East Pye Solar EN0110014

BEPS RESPONSE ON DESIGN, THE WORKS PLAN AND THE DRAFT DEVELOPMENT CONSENT ORDER

Cross-reference of APP/7.17, APP/7.18, APP/2.3 Revision B and Draft DCO Revision 2

Submitted by BEPS (Block East Pye Solar [REDACTED])

- LEGEND**
- Order Limits
 - Existing Landscape Features and Designations**
 - Existing Vegetation Cover
 - Ancient Woodland
 - Veteran Trees
 - Watercourse / Waterbody

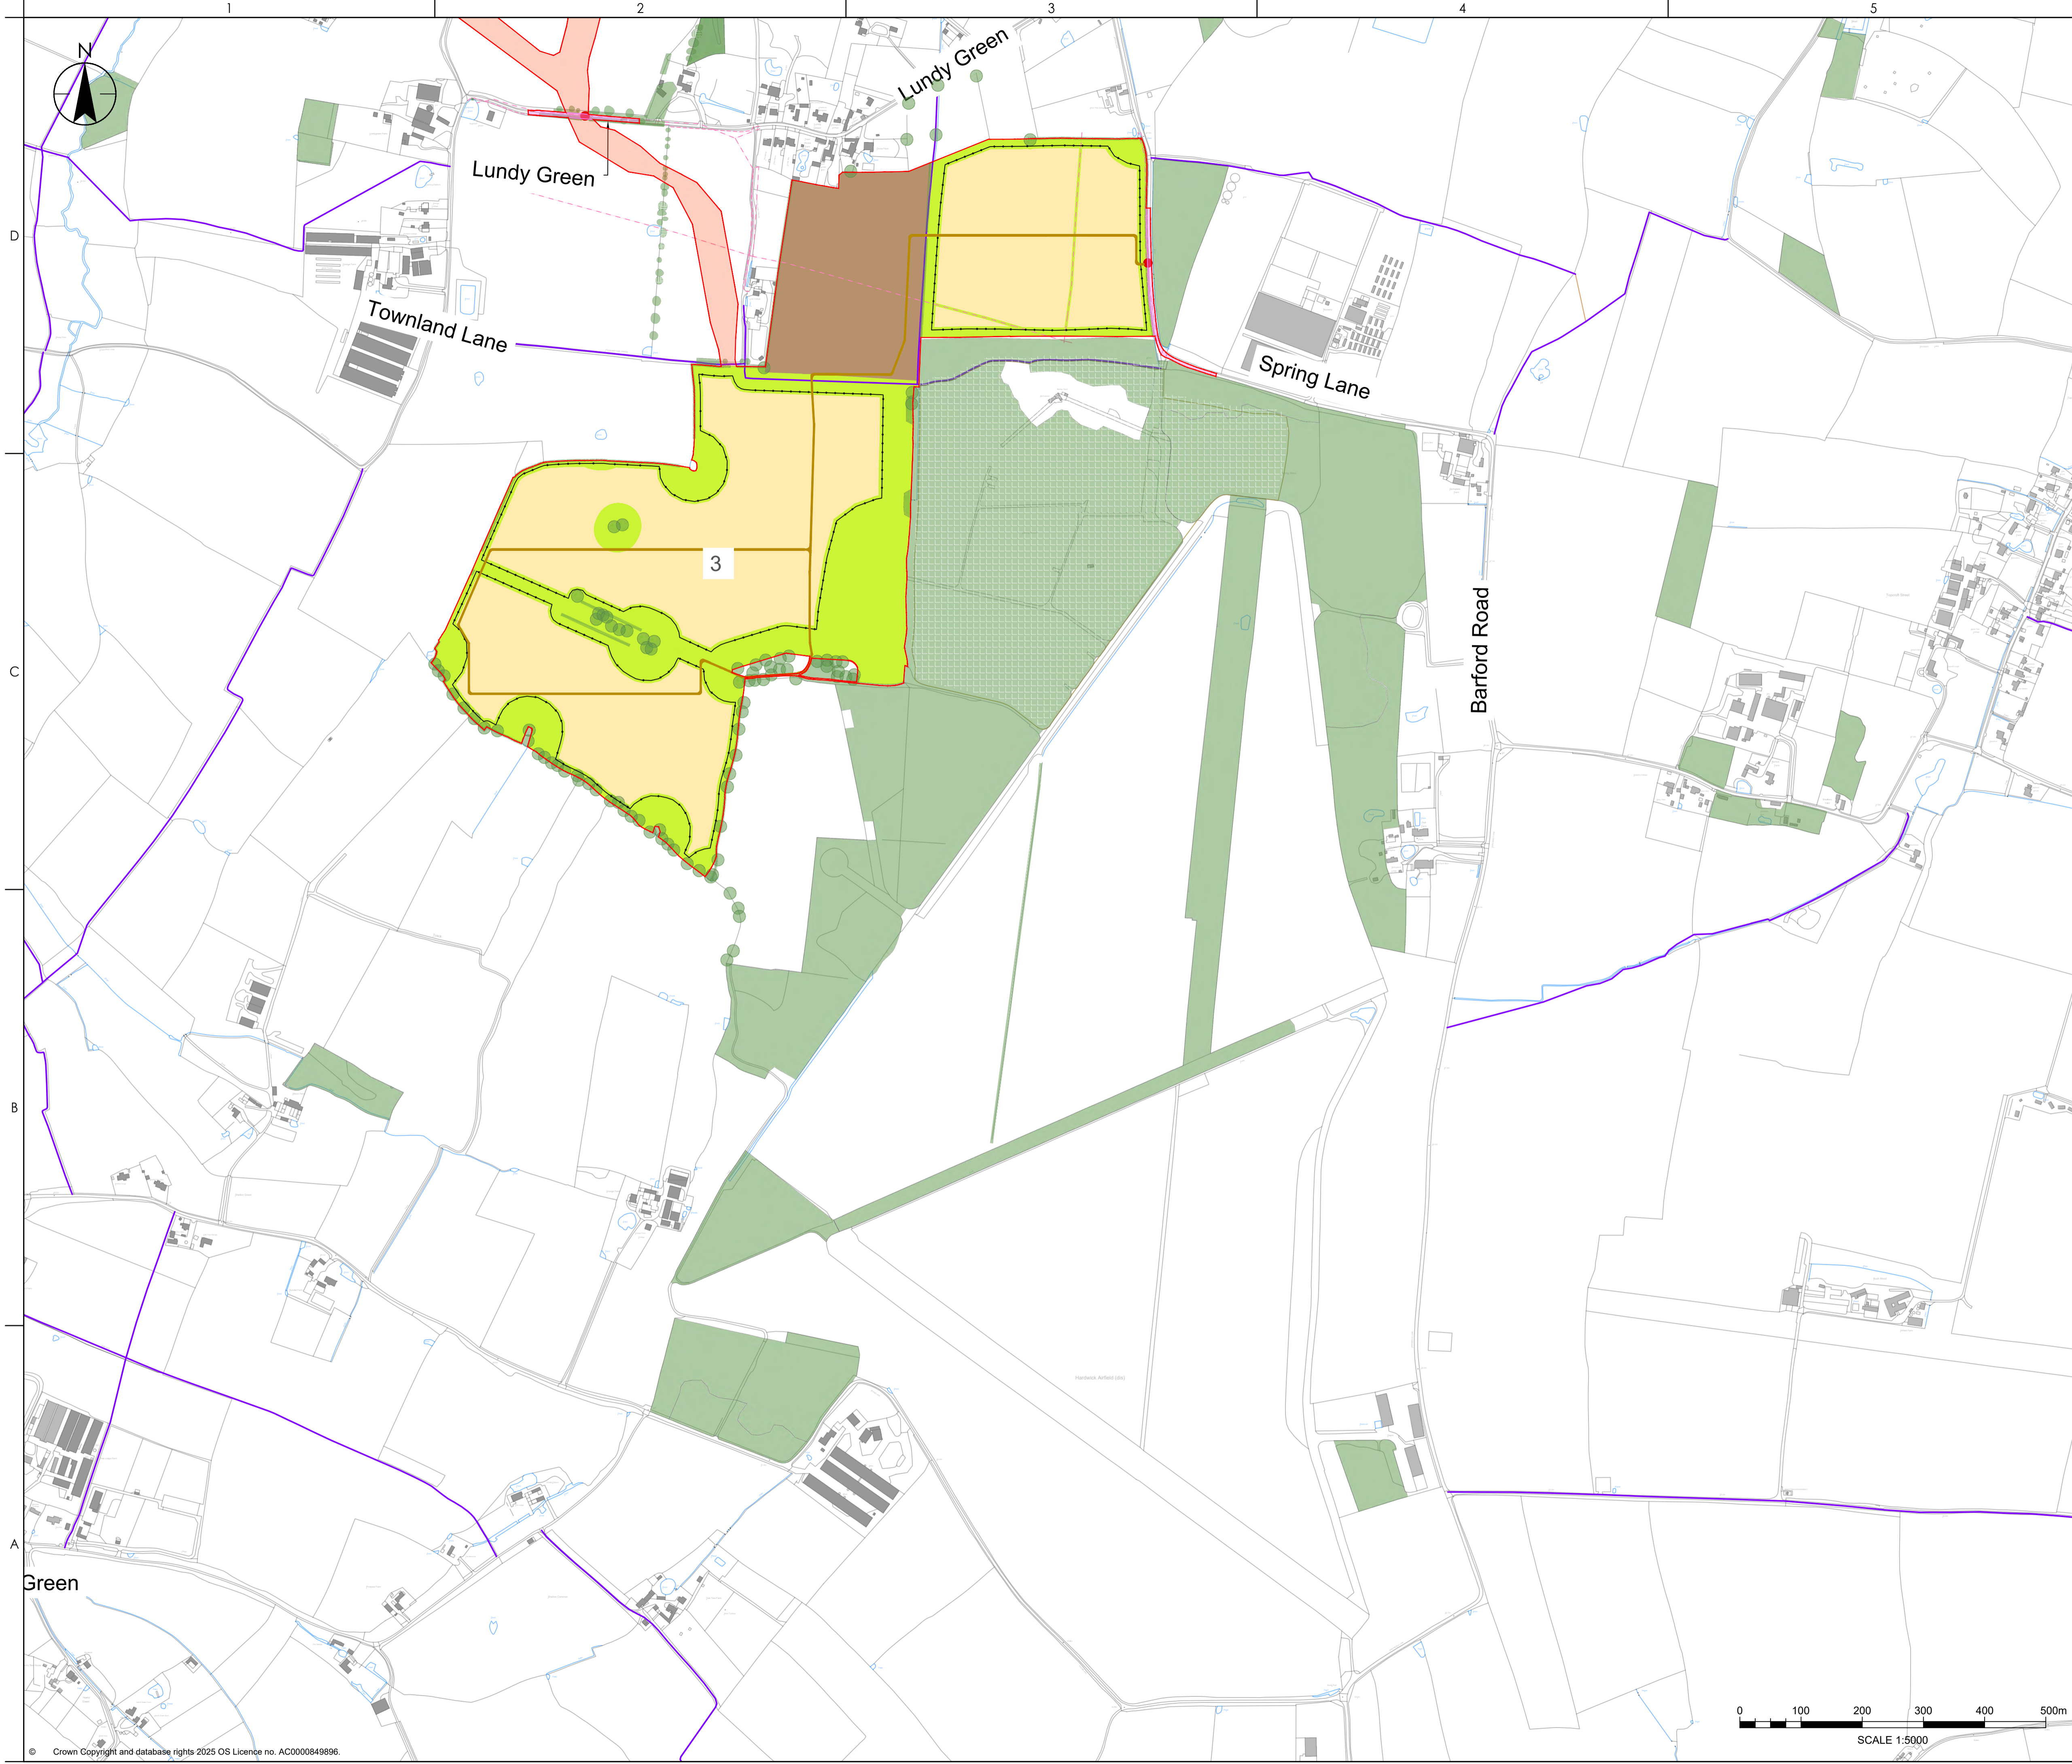
The DAD uses the Indicative Masterplan to demonstrate design evolution and quality, but it is not the consented layout. Article 3 requires numbered works to be situated within the corresponding numbered areas on the Works Plan. The Works Plan therefore defines broad envelopes, often with several Work layers over the same land. The correct test is whether any detailed layout lawfully available inside those envelopes remains within the reasonable worst case assessed by the ES.

BEPS asks that every design benefit shown only illustratively be accompanied by a simple schedule stating whether it is legally secured, by what provision and with what permissible tolerance.

The DAD presents setbacks at Sites 4B, 5 and 7 and increased mitigation at Site 3 as successful design evolution. The ExA should distinguish between screening or offset and genuine avoidance. Where the heritage or ecological case depends upon a setback, the setback should be a fixed minimum control rather than only an Indicative Masterplan feature.
